Our reference: ECM: 8974312
Contact: Gavin Cherry
Telephone: 4732 8125

28 January 2020

Re: Oakdale West Estate MOD 1 – Amendments to Approved Concept Plan and Stage 1 Works

Gavin Cherry
Development Assessment Coordinator

Typical Landscape Site Section

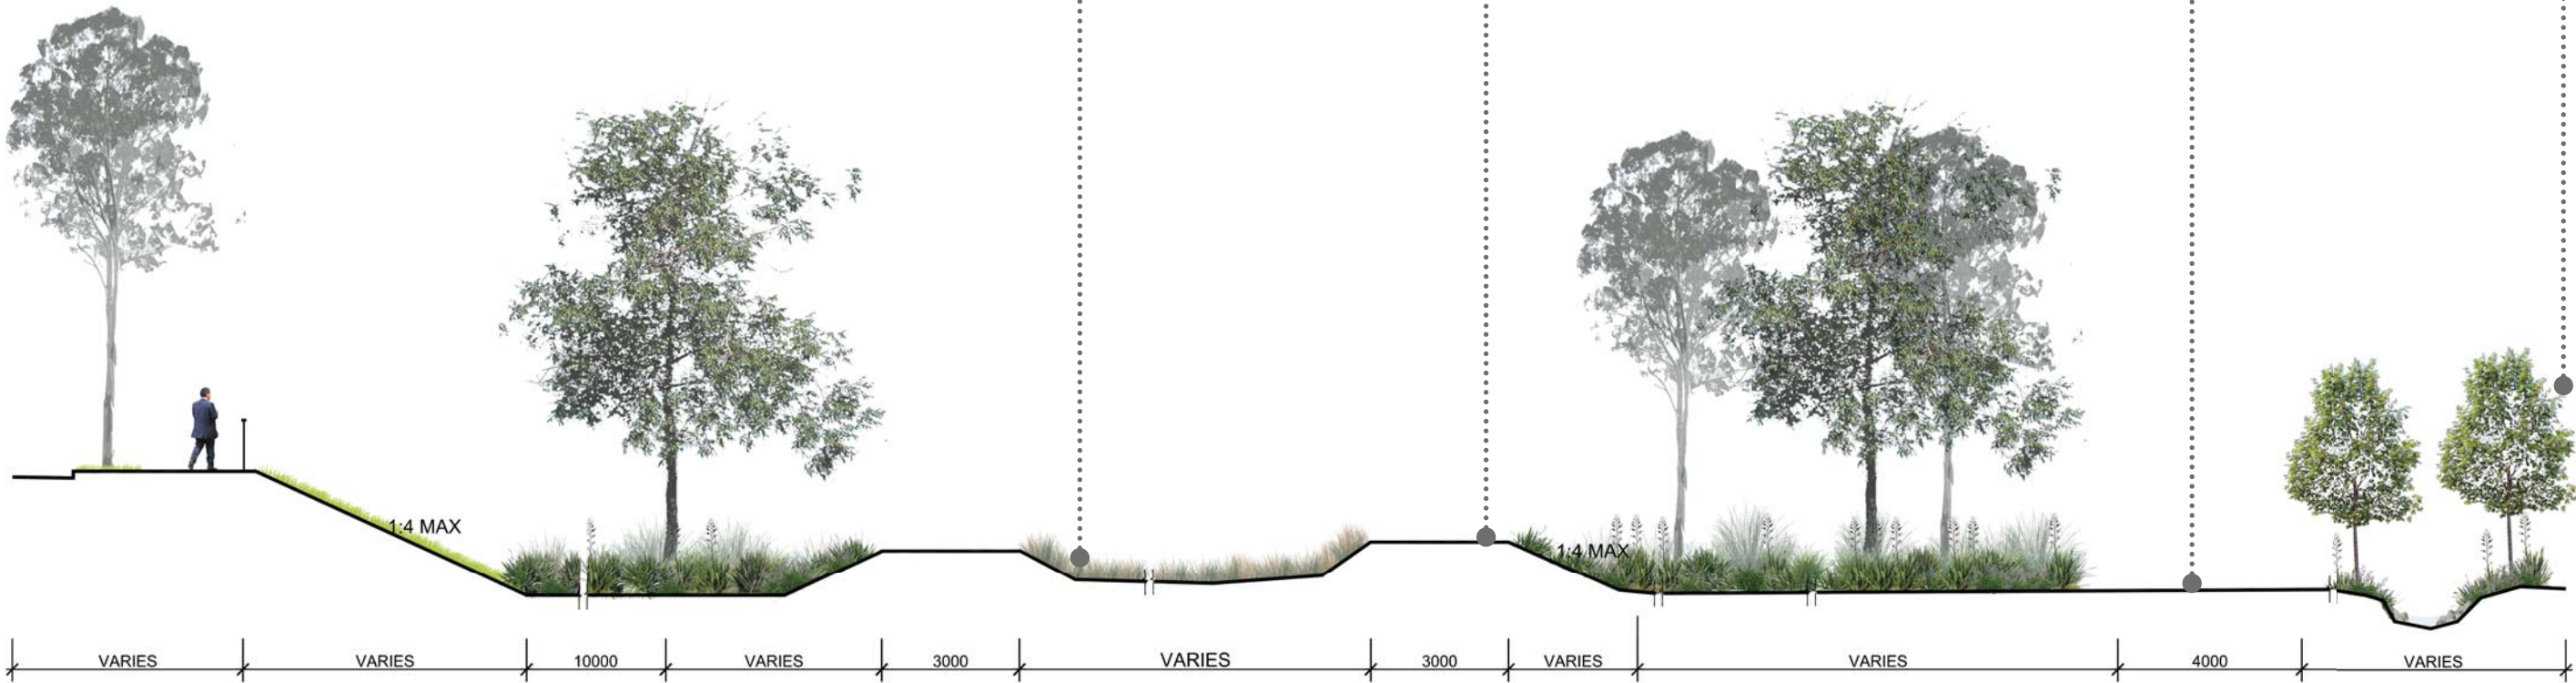
The design of the western bund maintenance track should include a requirement that the track be sealed to minimise the potential for scouring and erosion and to eliminate dust disturbance and to the adjoining school and retirement village. It is noted that this could be addressed as an additional / amended condition of consent if the modification application is supported.

Section AA (Western Boundary)
1:500 (Adapted from Civil section 1)

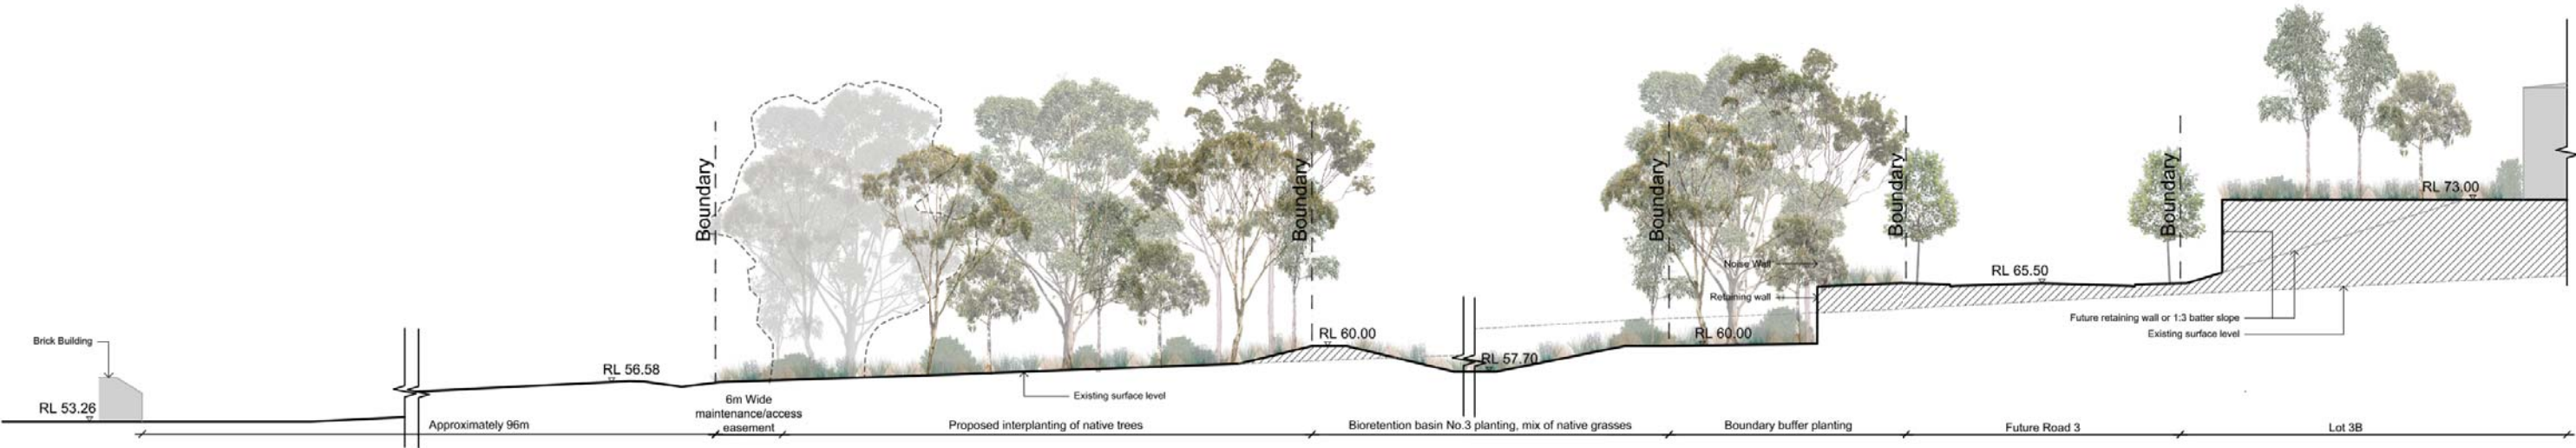
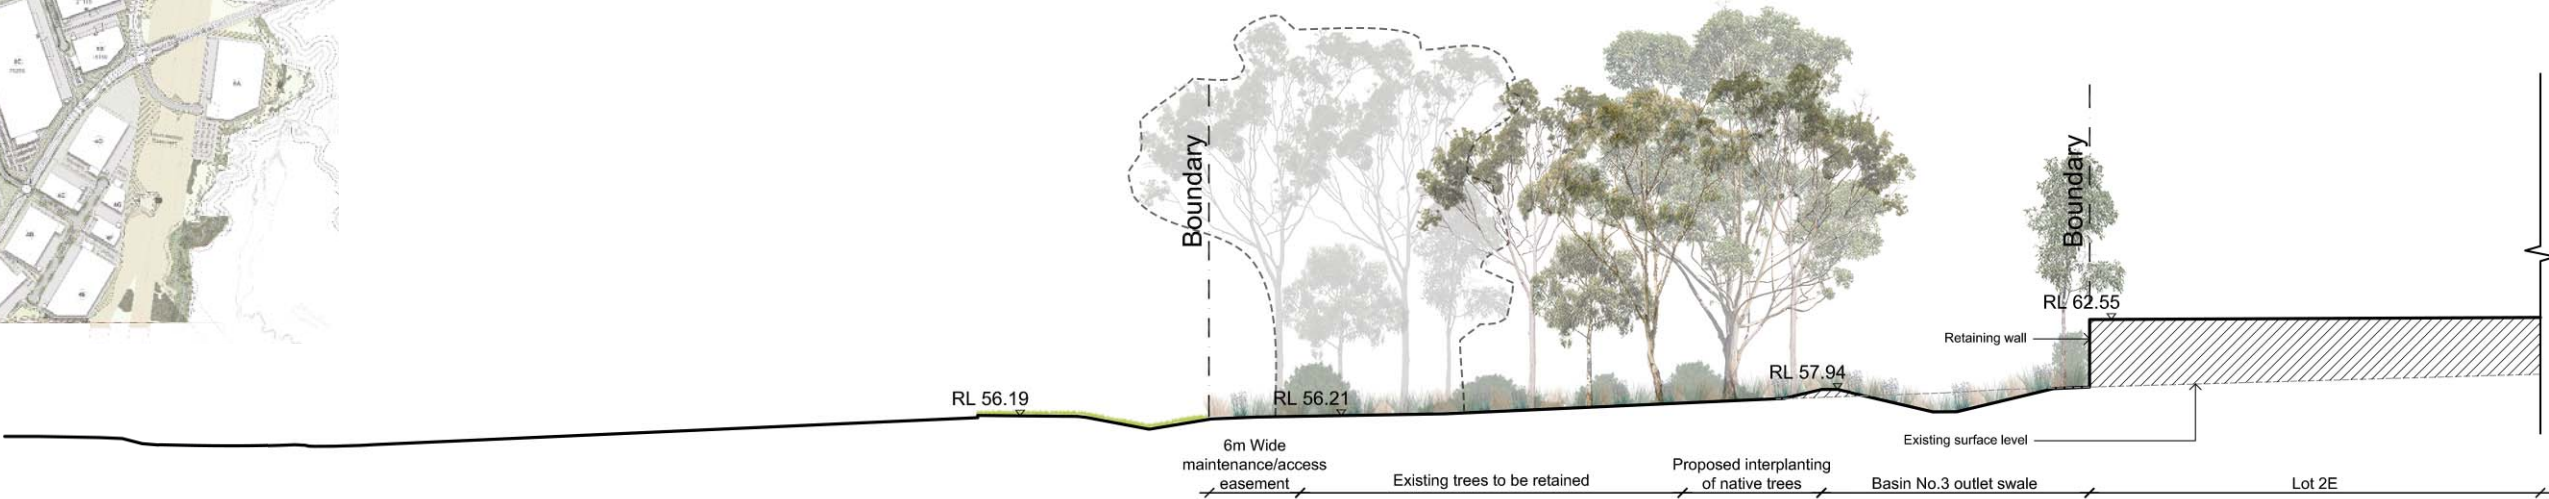
The approved concept plan and civil design drawing currently necessitate an internal design solution within approved Lot 2D (now indicated as 2A and 2B). The amended scheme essentially removes the onus on the developer / future applicants to manage gradient transitions within the boundaries of the approved allotments. Instead a minor level difference is provided west of Road 1 with a finished ground level of 66.20 which extends to the western edge of the western most allotment. This would appear to be designed to achieve relatively flat developable blocks however this desire necessitates an excessive and unacceptable retaining wall presentation (RW02) adjacent to existing development west of the precinct.

Retention of finished ground levels as approved, or similar to what is approved, is considered essential for all lots west of Road 3, with gradient transitions to be managed through future Development Applications within the confines of allotments, not additional imported fill presenting adverse visual impact external to the allotments.

The elevated nature of development within the allotments, is also likely necessitating acoustic walls of 5.0m on top of the retaining walls. This further reinforces that the fill activities are not only resulting in a poor interface and presentation outcomes as viewed from existing developments to the west, but the fill will also set up future acoustic management issues, as a 5.0m wall on top of an excessive retaining wall is not a suitable planning outcome given the zone and development interface. The information submitted also suggests that neighbour engagement is ongoing for further 'receiver' mitigation measures which would suggest that those proposed measures may not be sufficient to address and manage noise impacts external to the site. The scale relationship of this fill and the visual presentation of the proposed retaining wall and acoustic fence is best reflected on the landscape sections (AA) and (BB) which provided a finished ground level above the roof of the adjacent residential dwellings.
